From: Amanda Scholes on behalf of Planning.Responses
Sent: 26 September 2018 09:07
To: Planning Scanning
Subject: FW: Application Ref : FP/171/18/PL

From: Dawn Martin [REDACTED]
Sent: 25 September 2018 08:49
To: Simon Davis
Subject: Application Ref : FP/171/18/PL

Please refer to:-
Location Plan 17094-SK-003 dated 25/07/18

NEW DWELLINGS LAND AT WELLERS CLOSE FELPHAM BOGNOR REGIS		Drawing	LOCATION PLAN	
Client		Job-Dwg Number	17094-SK-003	Rev. -
Status		JAMES POTTER ASSOCIATES		
Scale		NTS	Sheet Size	A3
Author		RH	Checked	JP
		Date	19/12/17

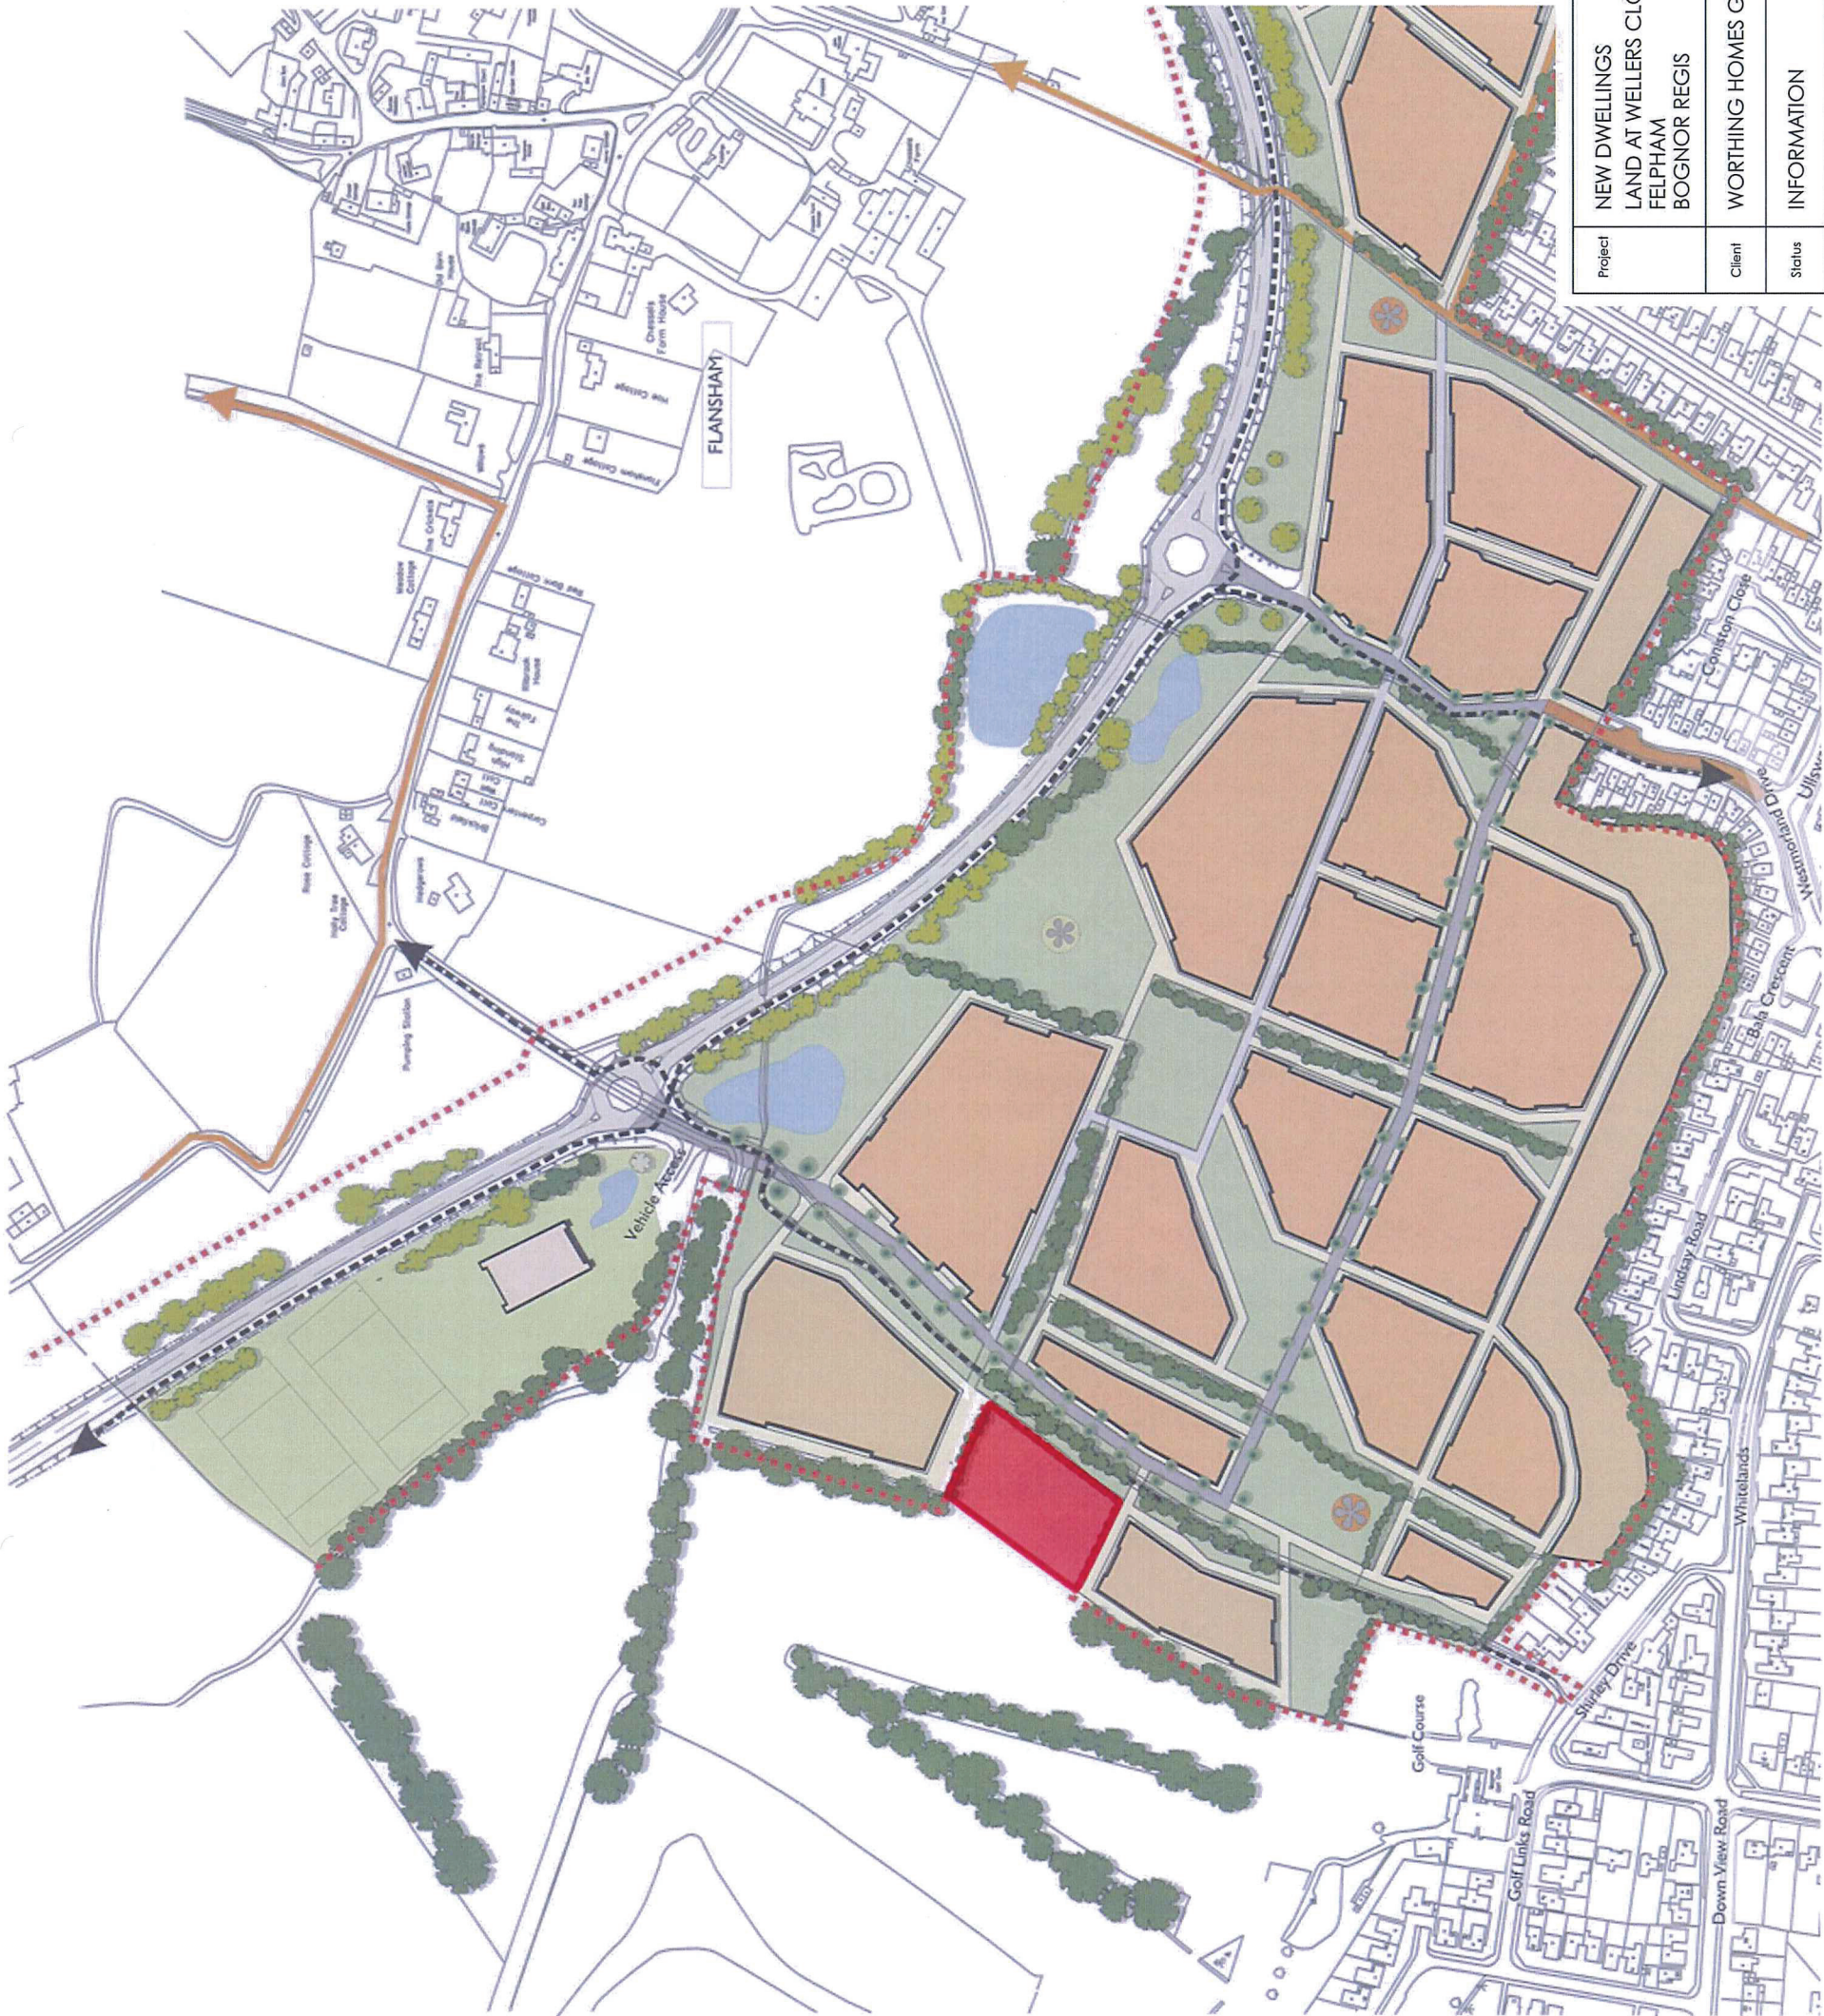
On this document there is a definite space around the proposed development. Why have the planners not adhered to this? At present the proposed development is outside these boundary lines and actually joins the properties in Wellers Close. Reducing to the size stated in the plans would increase the DPH.
